Re: SSI-10055; Albury to Illabo (A2I) Inland Rail Project; EIS Submission 28 September 2022

**Ref: SWT20/00080 | SF2020/128085**

FIGURE 7-2 INDICATIVE TRACK LOWERING

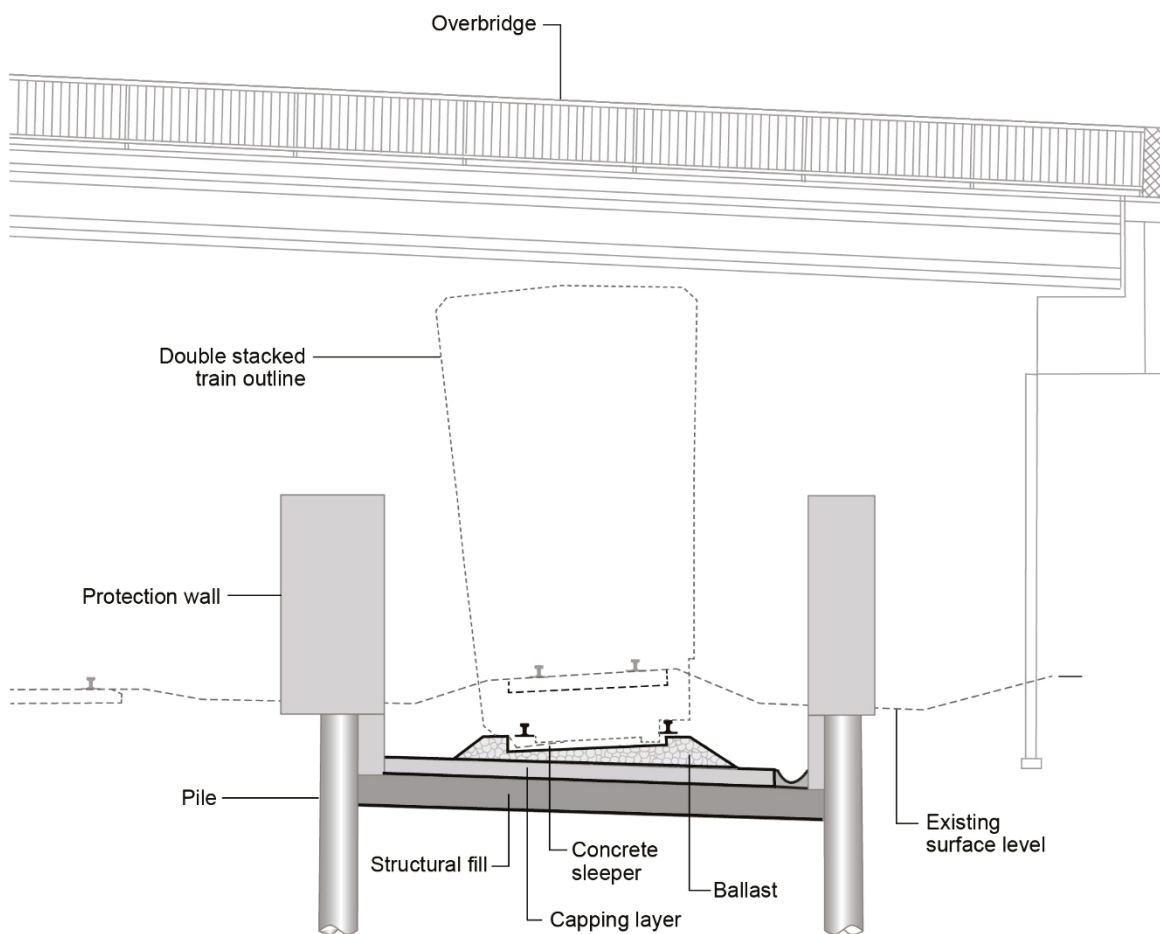
| Chapter  | Topic                                | Issue  | Transport Position and Submission Request  |
|--|--------------------------------------|--|--|
| <ul style="list-style-type: none"> <li>Chapter 6</li> <li>Chapter 7</li> </ul>   | Traffic & Transport (Track Lowering) | <ul style="list-style-type: none"> <li>Track lowering will impact the existing rail over bridges.</li> <li>Track lowering figure 7.2 is misleading as it does not show protection wall at minimum depth as per AS5100, does not show how far the new piles from the existing bridge abutment and does not accurately reflect the depth of track lowering required.</li> <li>Bridge replacement has been considered at each bridge enhancement site along the proposal. The EIS does not provide any justification as to why this option was not considered at the Pearson Street bridge enhancement site</li> </ul>                                      | <ul style="list-style-type: none"> <li>An assessment of the existing structure is necessary for drainage and location of new piles in the vicinity of the abutment.</li> <li>Proponent to provide additional information on how the risk of overland water flow would be managed, including specific details on proposed pumped drainage solutions, at enhancement sites where track lowering is the preferred option and similar site constraints exist.</li> <li>AS5100 section 15.3.4 (e) specifies that the "Protection Wall" shall extend a minimum of 1.2 m below ground level. The proponent to confirm that the protection wall will conform to Australian Standards.</li> <li>Proponent to provide justification for track lowering rather than bridge replacement at Pearson Street enhancement site.</li> <li>Proponent to provide justification for bridge replacement rather than track lowering at Edmondson Street enhancement site.</li> </ul> |
